RE: Griffith Mercer Island House Deck Remodel
2443 84th Ave SE
Mercer Island, WA 98040
Permit Number: 1906-185
SUB4-PLANS REVIEW RESPONSE

The following are “Jackson Main Architecture” (JMA) responses to the plan review comments raised in the “**SUB-4 Plans Review**” plan review document, sent on **July 9, 2020**. Responses to the review comments are numbered to correspond to the appropriate number in the review comments for the project referenced above.

A0.01

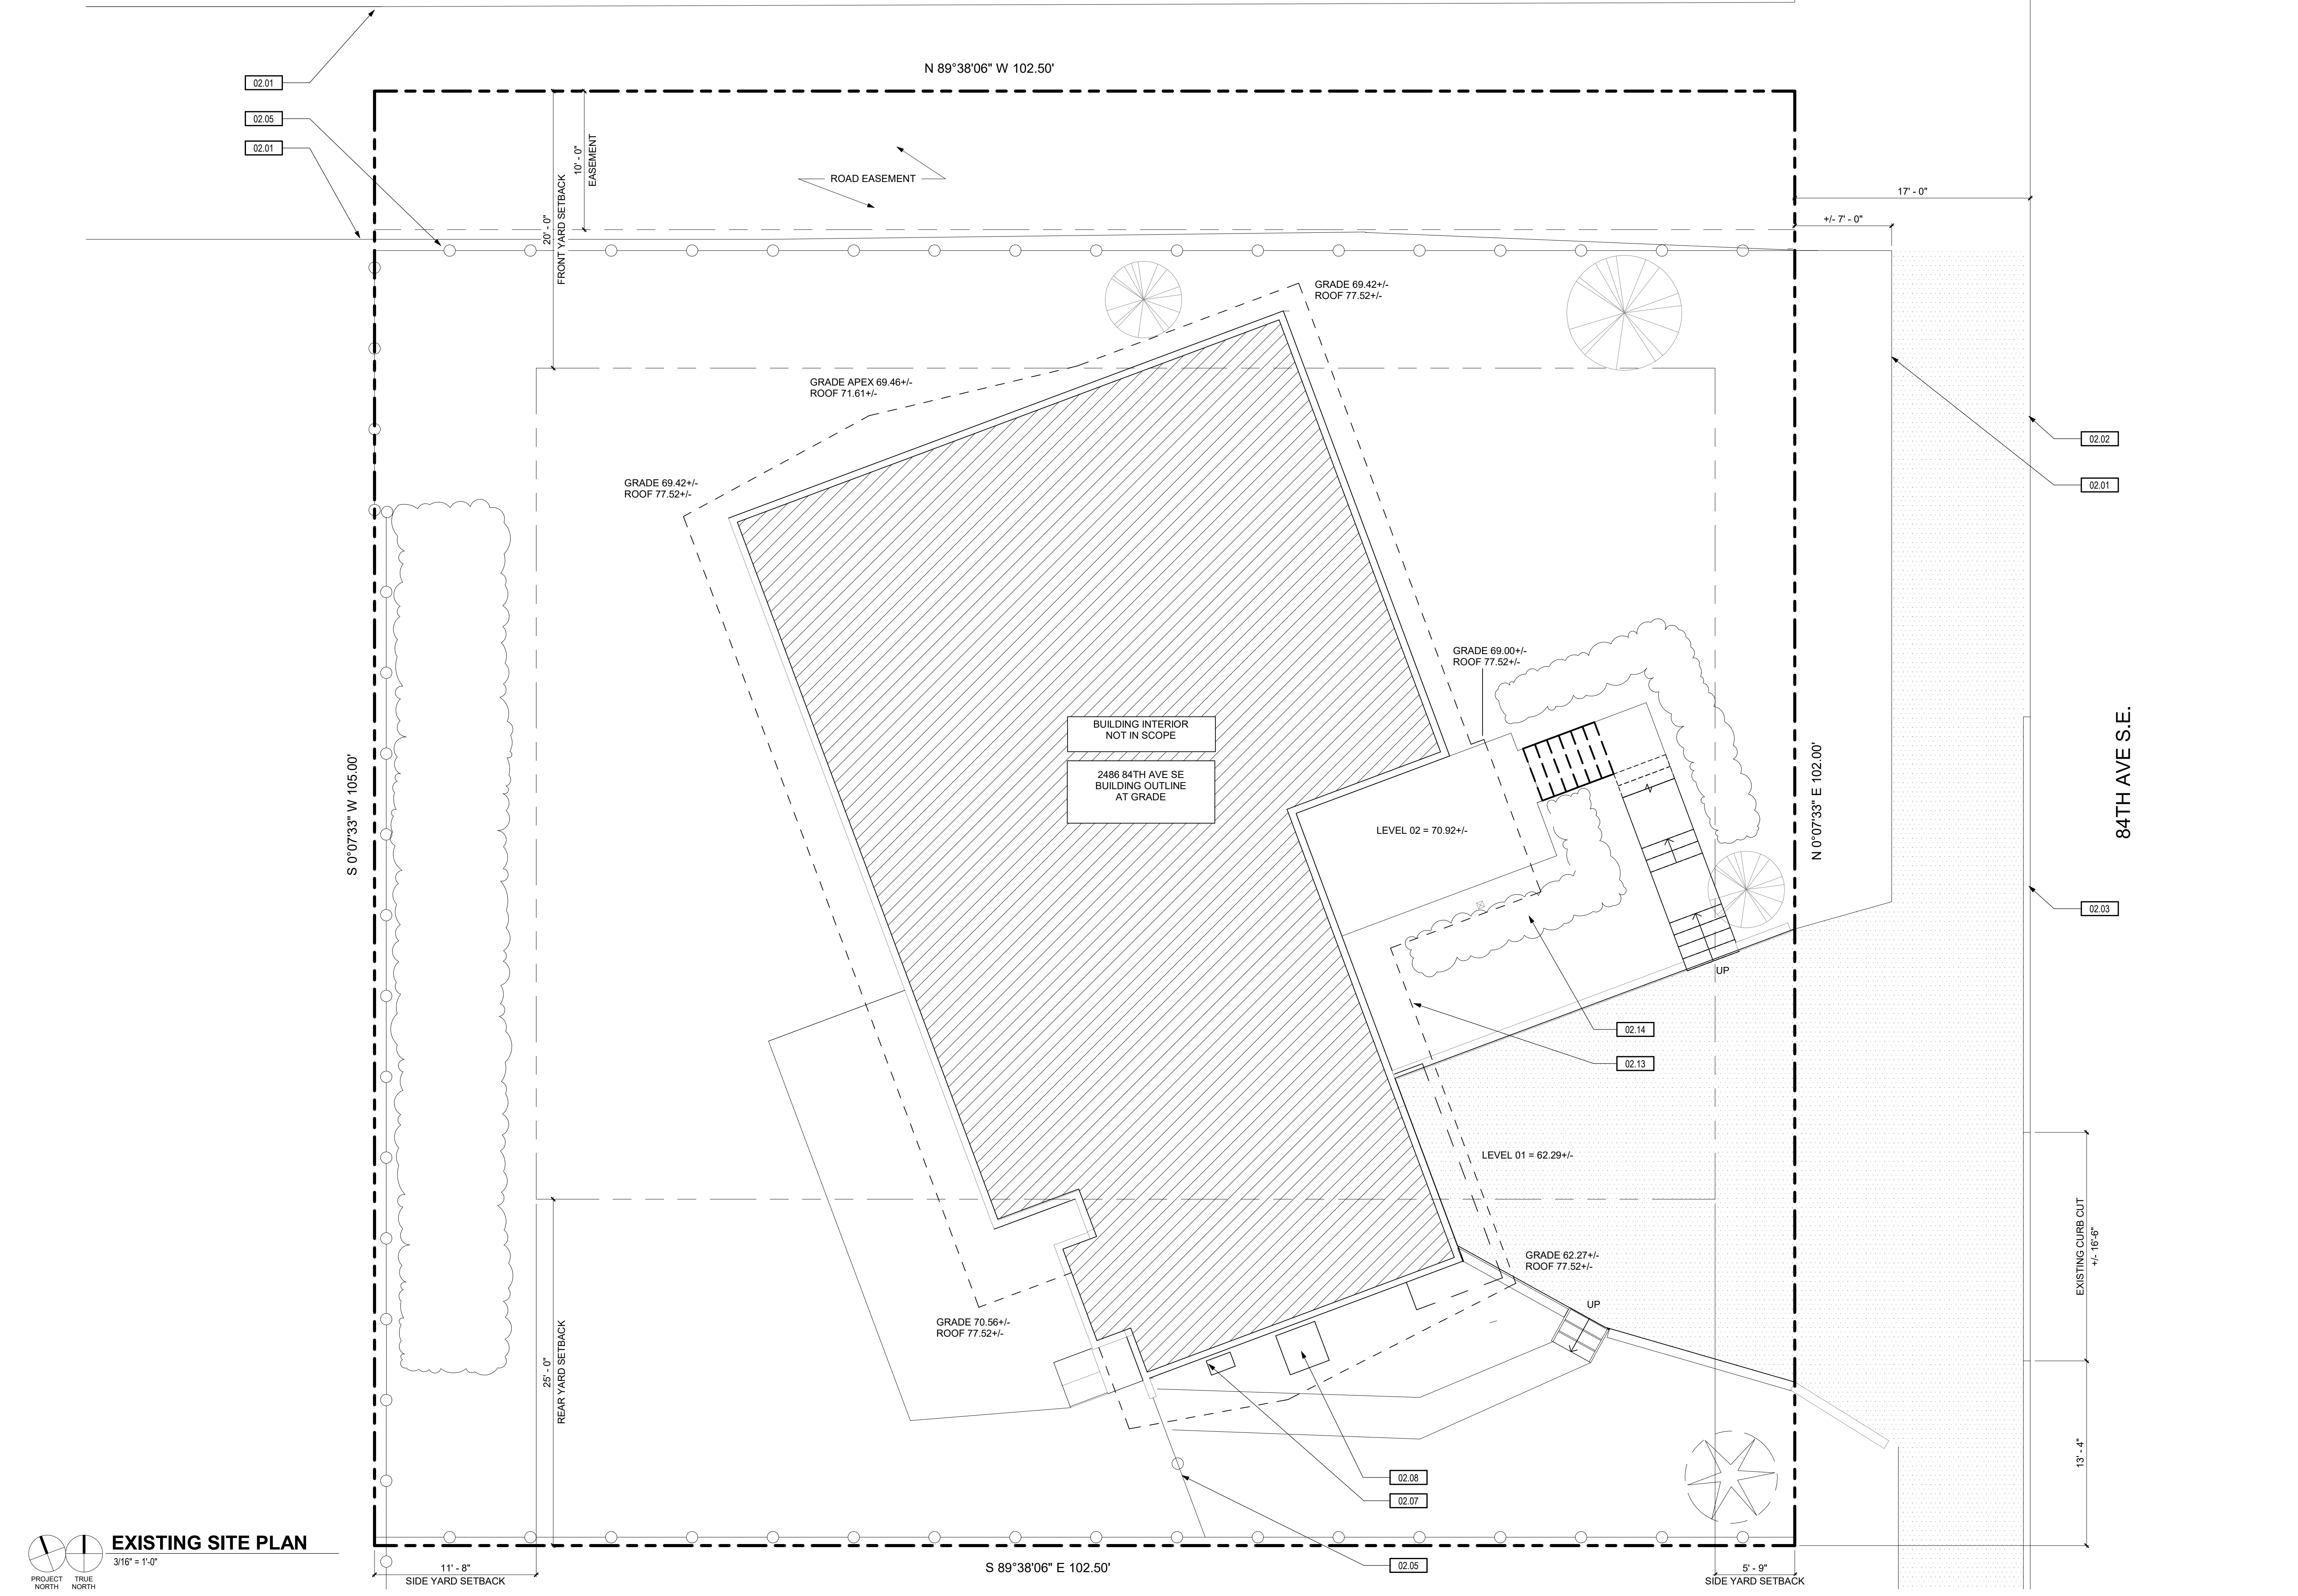
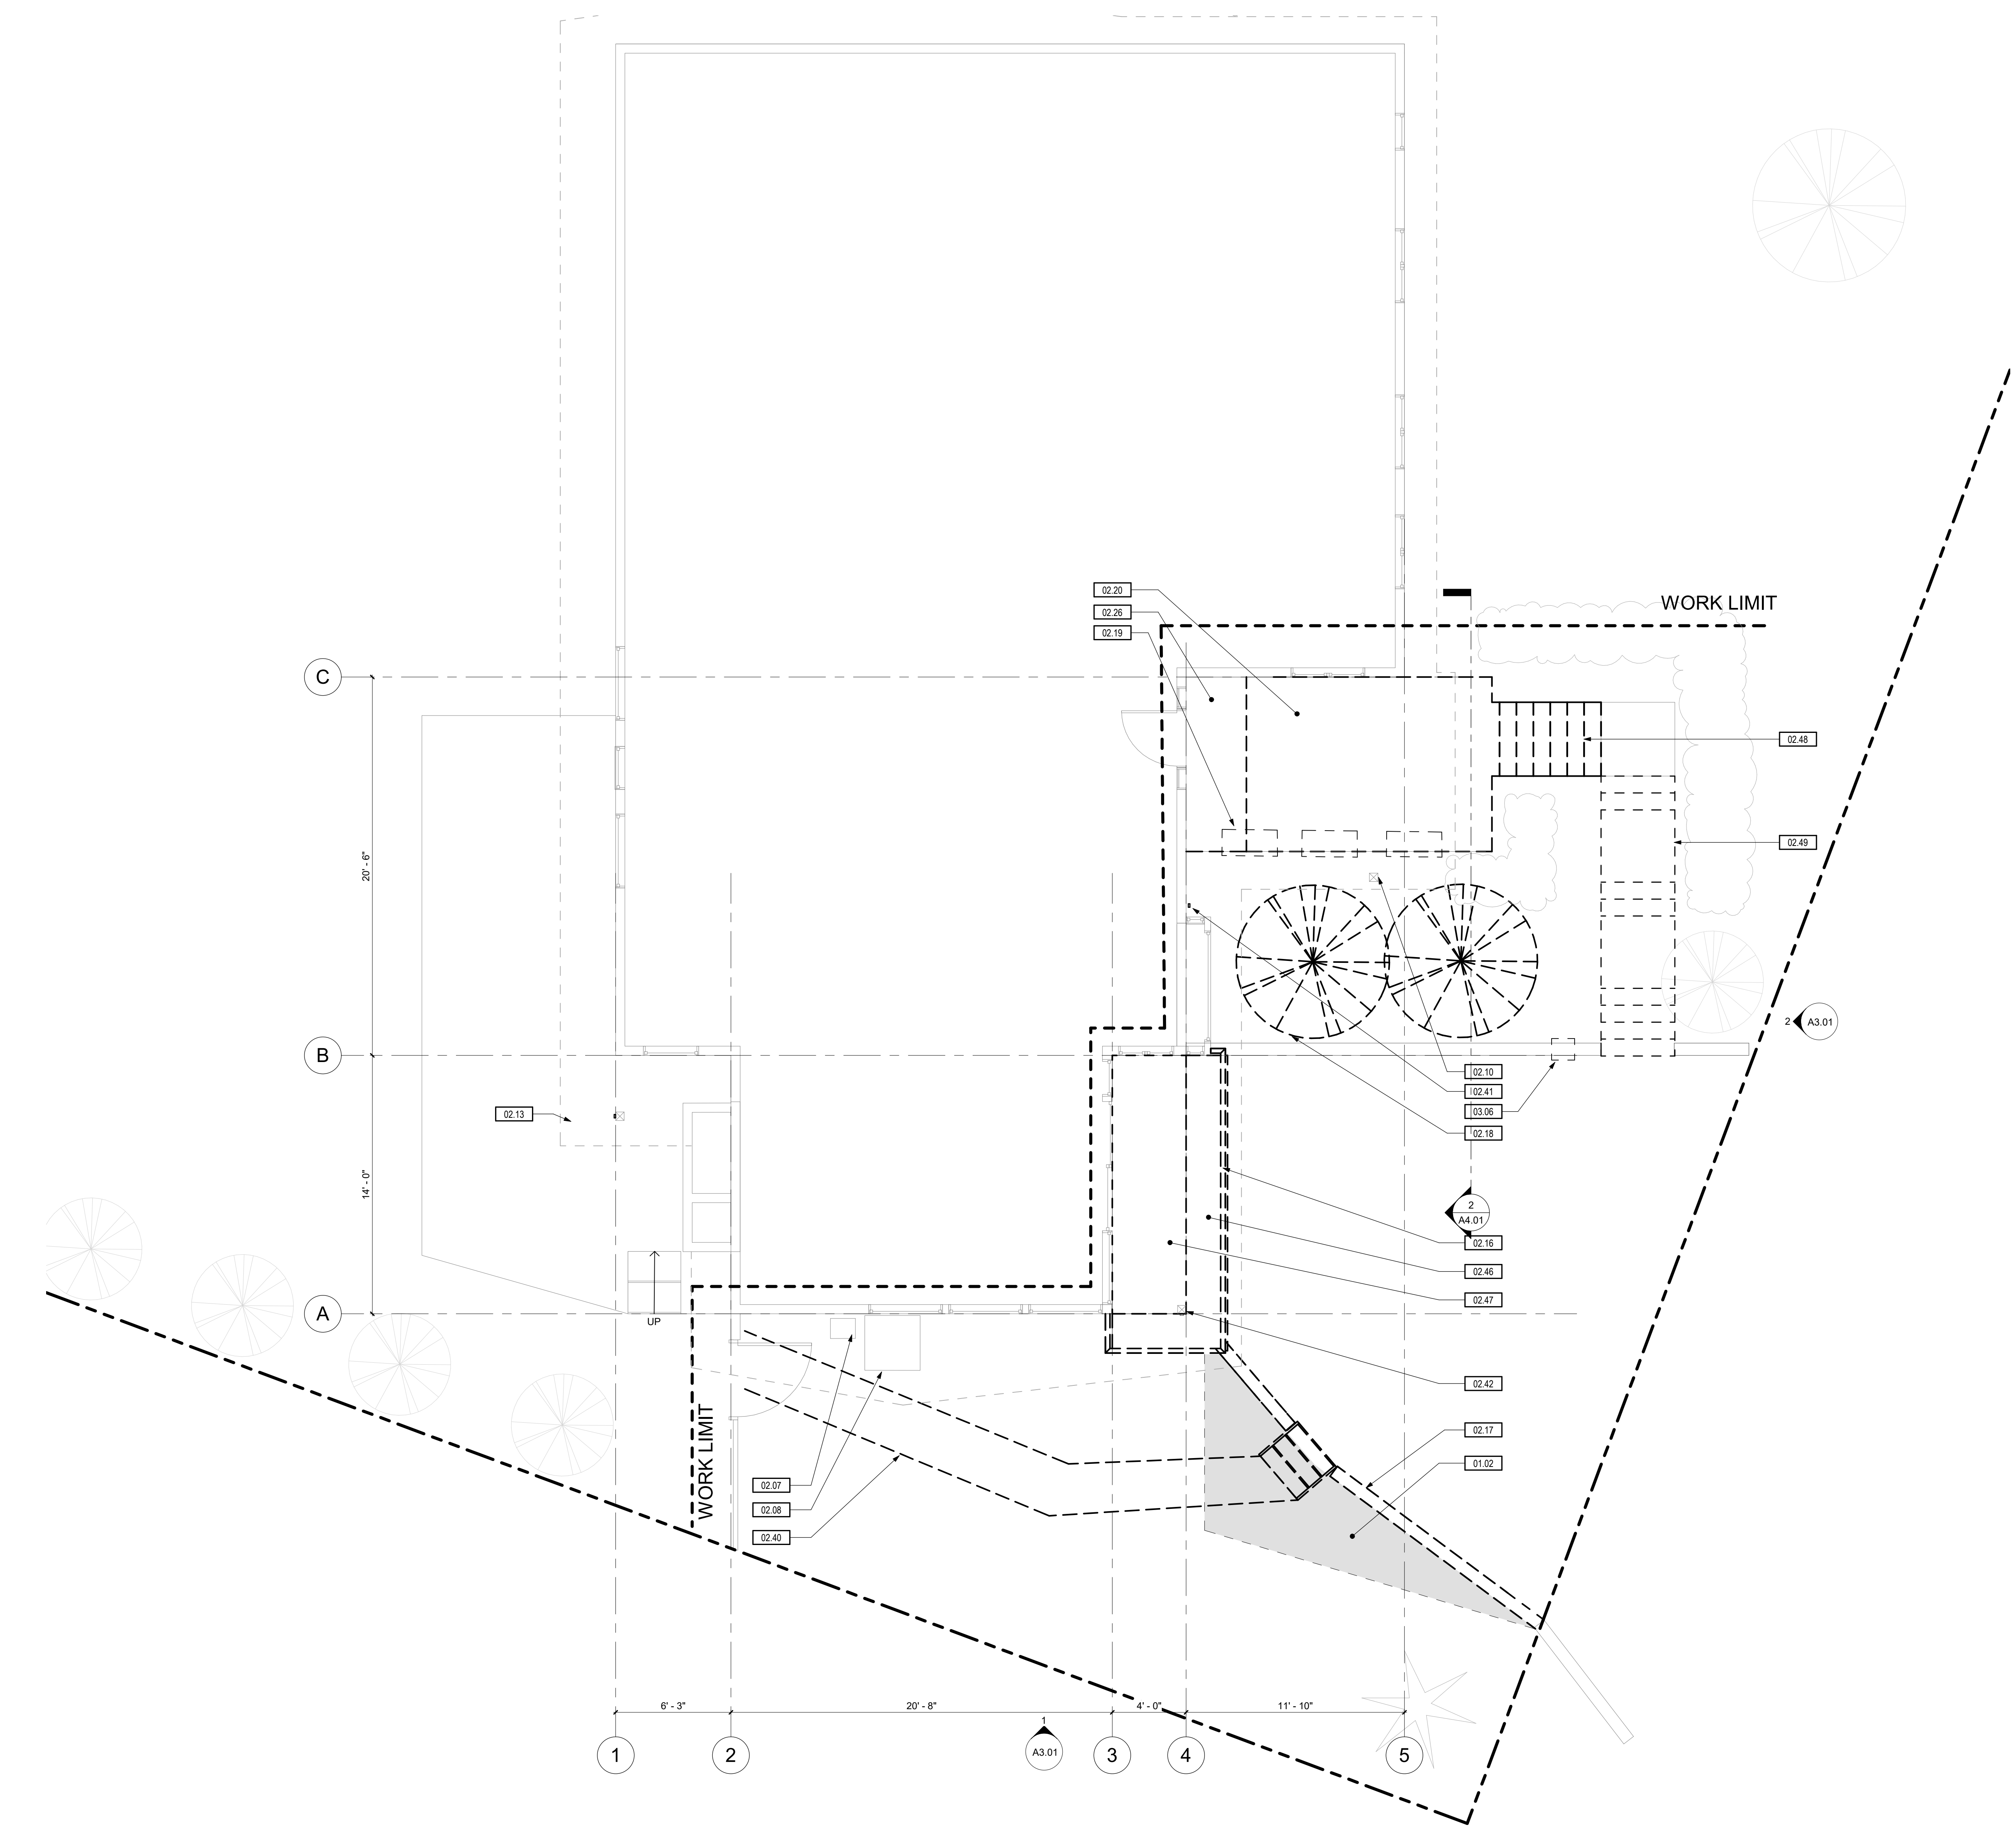
2. *An updated Site Development Worksheet (not a site plan) was requested in SUB3 and was not provided. Please provide this updated document to reflect the revised lot coverage, hardscape, and lot slope calculations.*

4. *This is being shown as "lot coverage removed" - was there building here? Or was it a walkway? If it's building or as a roof it's lot coverage, if it was uncovered stairs it is hardscape.*

5. *Please provide the following on the new proposed site plan that's being requested: lot coverage & hardscape*

6. *Please remove this note as it is incorrect. All decks (no matter the spacing) are considered 100% hardscape. The code section referenced here is incorrect, as that only applies to regulated improvements such as schools and religious buildings.*

Jackson Main – Sara Vernia (JMA3): Please see attached as well as updated diagrams on sheet A0.01.

Diagrams were updated, see sheet A0.01. The stoop demolition was removed from the lot coverage calculations and shown in the hardscape diagrams.

Diagrams demonstrating lot coverage and hardscape are provided on sheet A0.01.

Noted. New uncovered deck now included in the hardscape calculations. Please see calculation worksheet and sheet A0.01.
